CITY OF ALBUQUERQUE

February 24, 2010

Re: James Monroe Middle School New Track and Field Grading and Drainage Plan

Engineer's Stamp dated 1-18-10 (B10/D004)

**GRADING
&
DRAINAGE
PLAN 01**

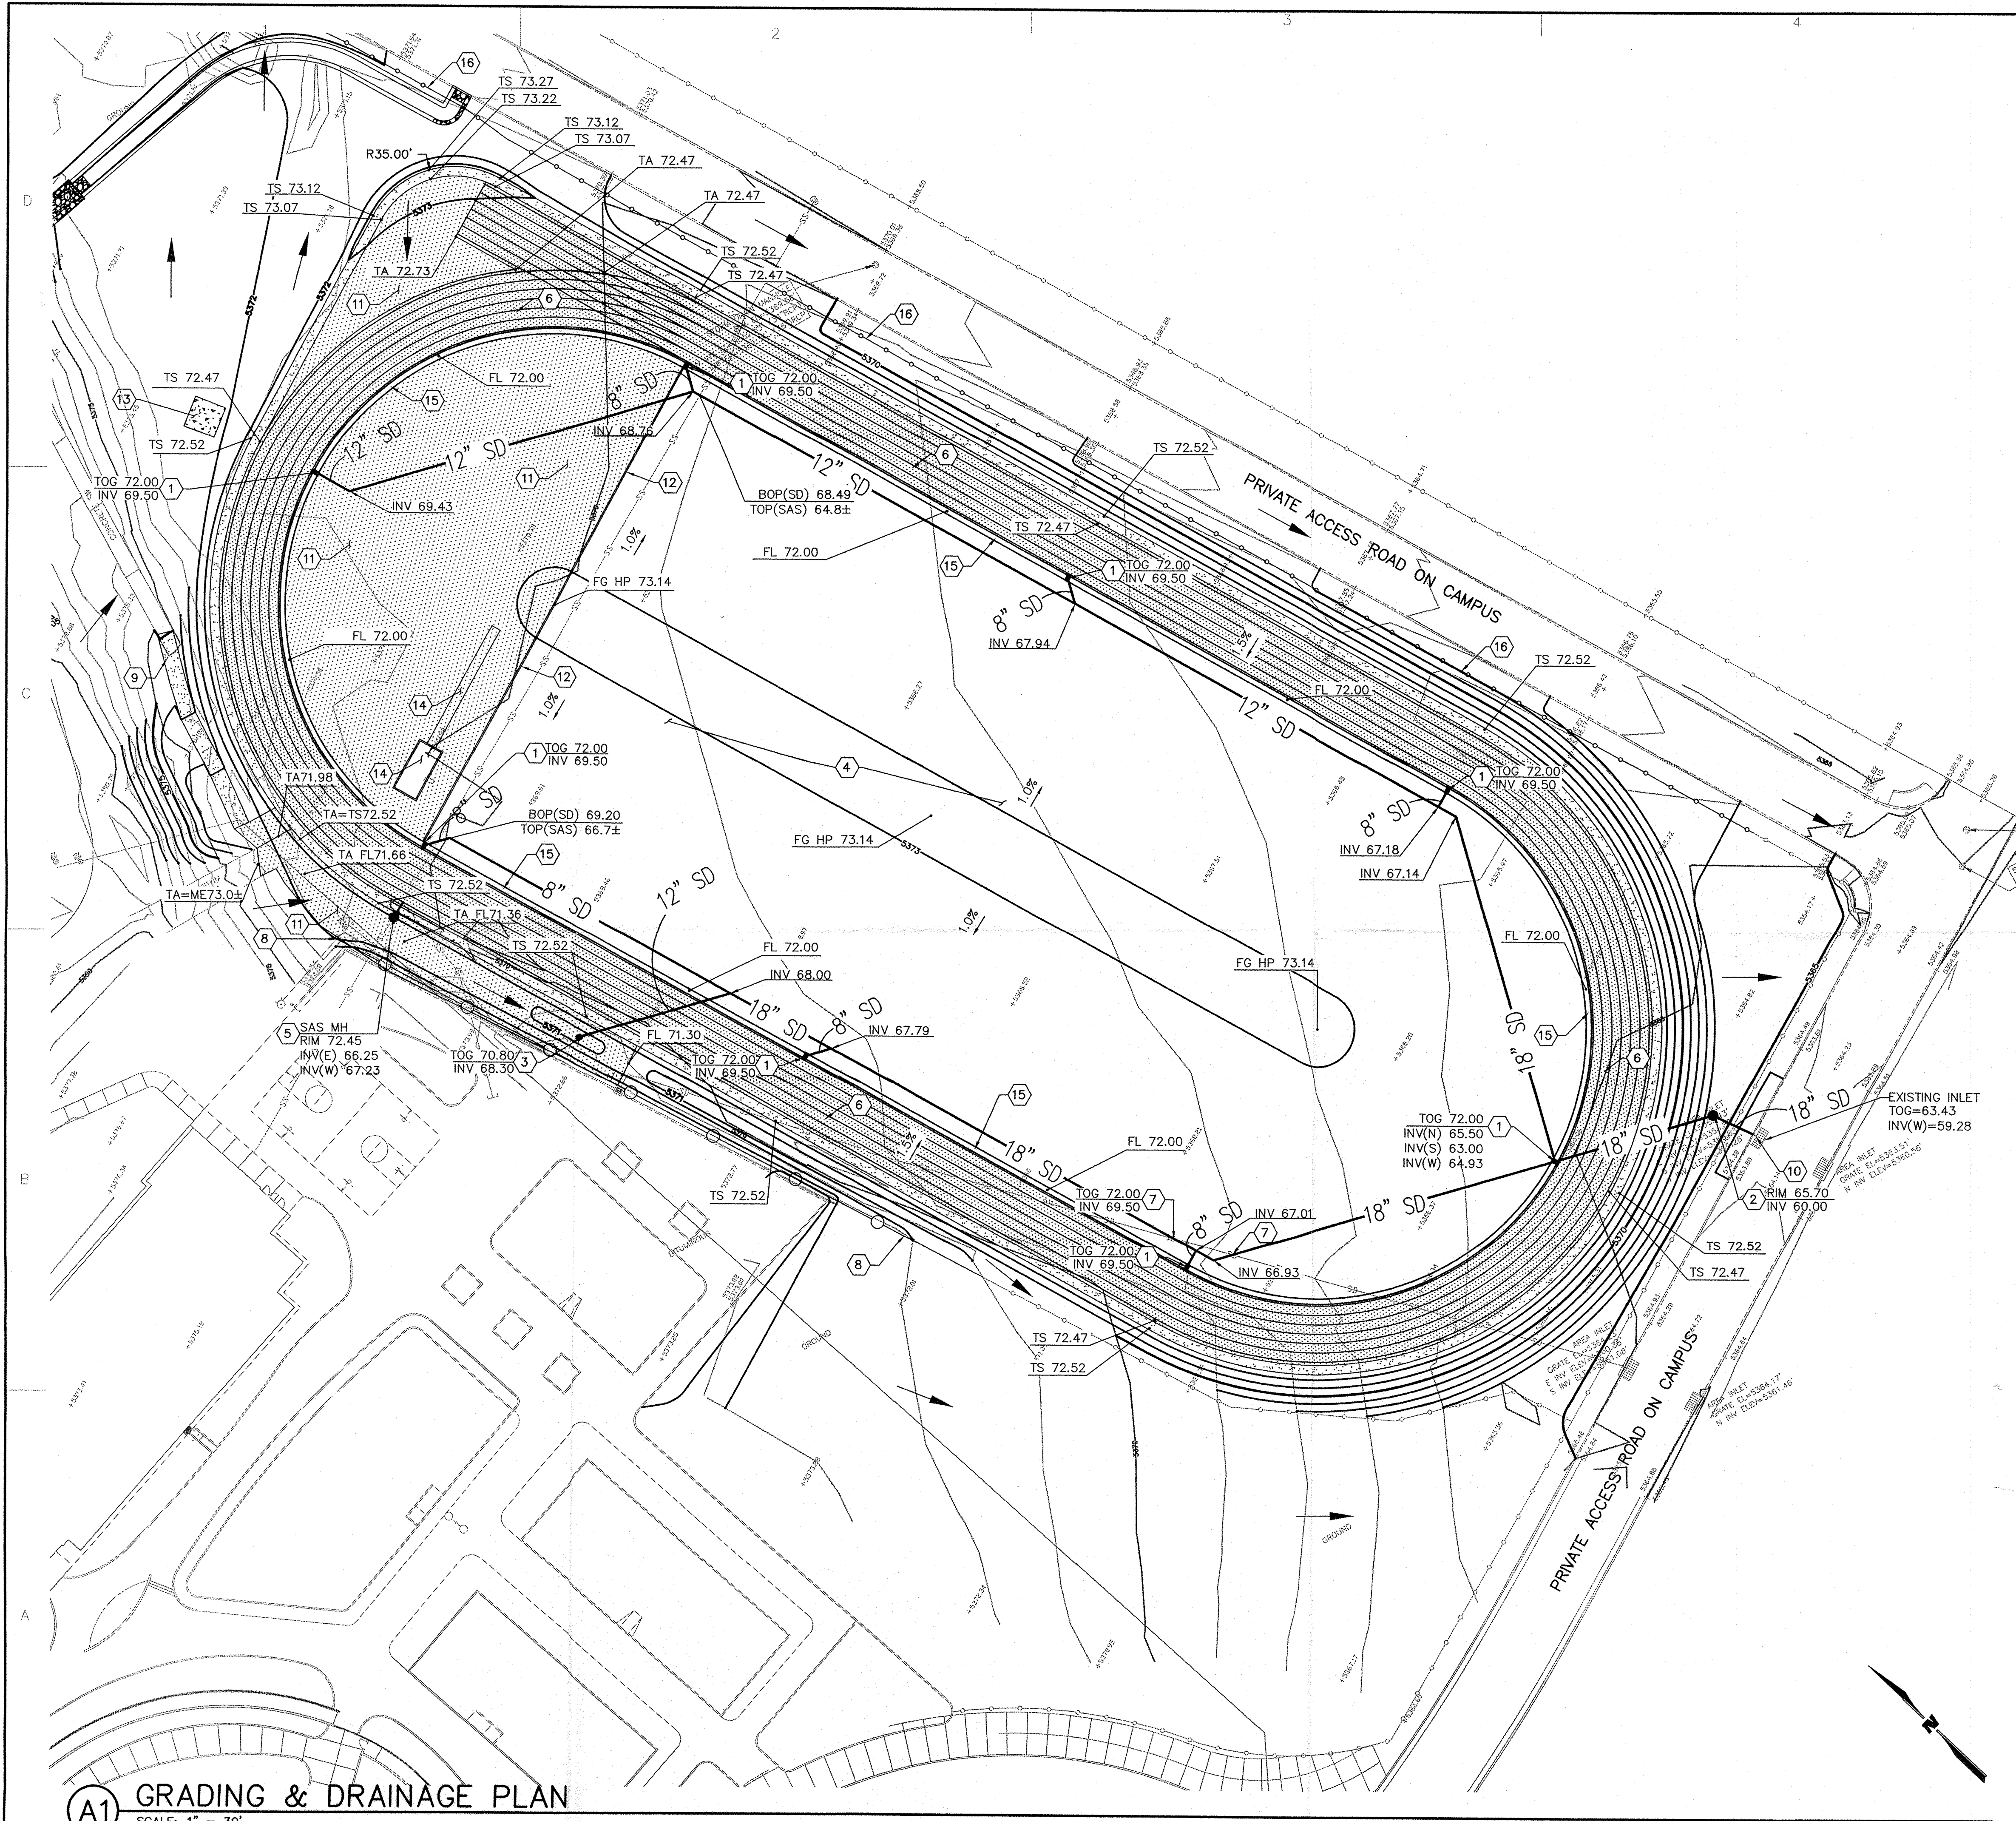
You may want to provide some means of erosion control on the slope around the south side of the track.
